**KIRKLEES METROPOLITAN COUNCIL
INVESTMENT & REGENERATION SERVICE**

DELEGATED DECISION TO DETERMINE PLANNING APPLICATIONS

Reference No:	2023/62/90659/E
Site Address:	3, Oxford Drive, Gomersal, Cleckheaton, BD19 4TU
Description:	Erection of single storey rear and side extension
Recommending Officer:	Katie Wilson

HOUSEHOLDER DELEGATED REPORT

Proposed Ground Floor Plan
 1:50

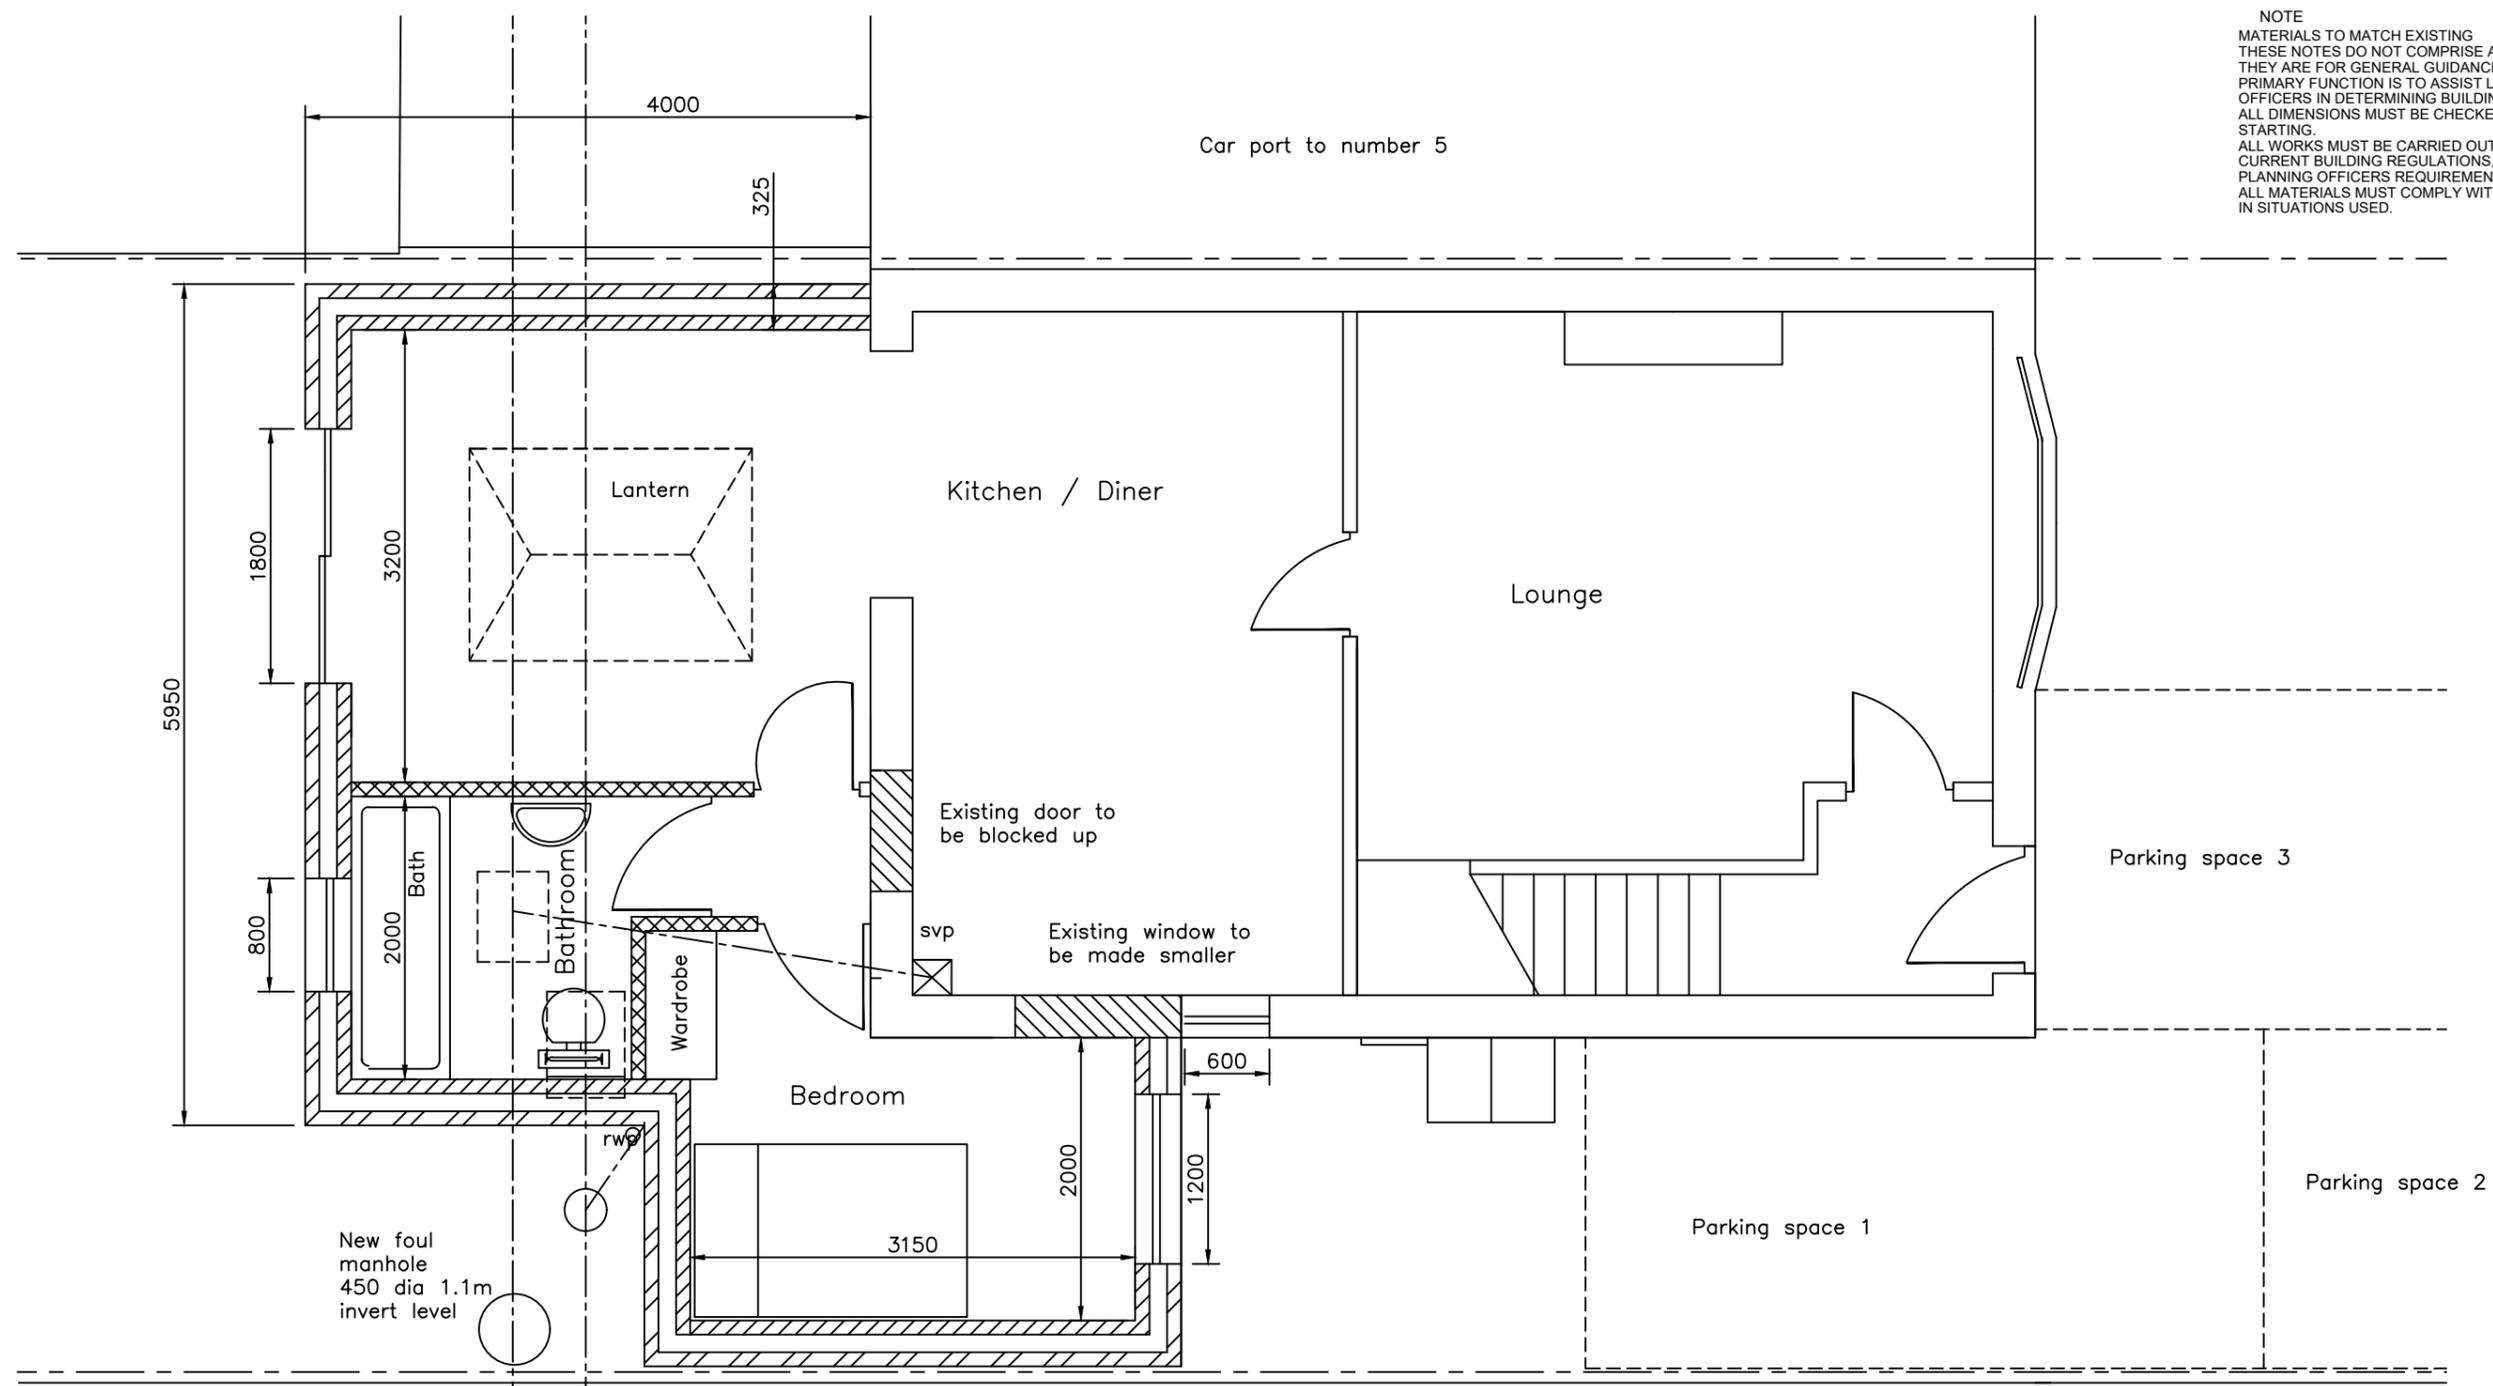
Single storey rear extensions should:	<u>Yes - COMPLY</u>	<u>No - JUSTIFY</u>
Be in keeping with the scale and style of the original house.	<p>Yes – original house is a modestly proportioned 2-storey detached house, with conservatory at the back.</p> <p>In terms of scale, the footprint of the proposed extensions would be significantly less than the original building and replace the existing conservatory. They would also be single storey. As such they are considered to be in keeping in scale.</p> <p>In terms of style, the proposed extensions would have a contrasting roof design (ie flat roof with lantern light, rather than dual or mono pitched). However, this design combination is increasingly seen in domestic situations and in this instance there are other examples in the area. As such the contrasting roof design is considered acceptable.</p> <p>The walls of the proposed extensions would be in matching brickwork, and window / door openings are considered acceptable for a domestic</p>

extension, as is the glass lantern light.	
Not normally cover more than half the total area around the original house (including previous extensions and outbuildings)	Yes	
Not exceed 4 metres in height	Yes	
Not project out more than 3 metres from the rear wall of the original house for a semi-detached or terraced house, or by 4 metres for detached properties		<p>No – the proposed extensions would project 4.0m to the rear and be close to the mutual boundary with 5, Oxford Drive.</p> <p>However, in this instance the neighbouring property at 5, Oxford Drive also has a single storey flat roofed extension at the back close to the boundary, which projects a similar distance. As such, it is considered that this provides adequate mitigation to justify not conforming with this element of the SPD and is considered acceptable.</p>
Where they exceed 3m in length the eaves height should generally not exceed 2.5 metres; and		<p>No – The proposed extensions would have a flat roof with eaves approximately 2.6m high.</p>

In officers' opinion the impact of this additional height would be miniscule and not cause harm to visual or residential amenity.
Retain a gap of at least 1 metre from a property boundary, such as a wall, fence or hedge.		No – The proposed rear extension would be adjacent to the property boundary. However, in this instance for the reasons given above, it is considered that there are mitigating circumstance providing justification for non-compliance with this element of the SPD.

Relevant key design principle (KDP) of the SPD, Policy in the Kirklees Local Plan and the NPPF	Further comments	✓ / X / N/A
Impact on privacy of neighbours (to northern and southern sides)	<ul style="list-style-type: none"> KDP 3 & 4 of the SPD Policy LP24 Design (d) (iv) Chapter 12 of the NPPF 	The proposed extensions would have walls close to the boundaries with neighbouring properties at 1 and 5, Oxford Drive. However, no openings

<p>are proposed in either side elevation. New openings could be controlled by condition, but in this instance because they are at ground floor level only and would look directly onto either fencing around 2.0m high or blank facing elevations at close quarters, it is considered that it would be unnecessary and so not meet the tests for planning conditions set out in the NPPF.</p> <p>Patio doors and a window in the rear elevation would look directly onto the back garden and boundary walling to cricket ground.</p> <p>Residential properties to the front and on the opposite side of Oxford Drive are a considerable distance away and unaffected.</p> <p>As such it is considered that the proposed extension would have no overlooking impact upon neighbouring properties.</p>	
<p>Impact on light and outlook of neighbours (to sides, rear and front)</p>	<ul style="list-style-type: none"> • KDP 4, 5, 6 of the SPD • Policy LP24 Design (b) • Chapter 12 of the NPPF 	<p>The proposed extensions would have a flat roof and overall height of around 2.6m.</p> <p>Whilst they would be close to the mutual boundaries with 1 and 5, Oxford Drive given that the latter already has a rear extension close to</p>

the boundary that projects a similar distance and the former would be affected by the proposed side extension, which would project just a small distance beyond the rear building line, it is considered that the overshadowing and overbearing impacts would be minimal.	
Remaining garden space of application property	<ul style="list-style-type: none"> • KDP 7 of the SPD • Policy LP24 Design (b) and (c) • Chapter 12 of the NPPF 	Although the proposed development would reduce garden space at the back, it would retain all existing at the front and much of the space to the side. As such it is considered that it would comply with the relevant policies.
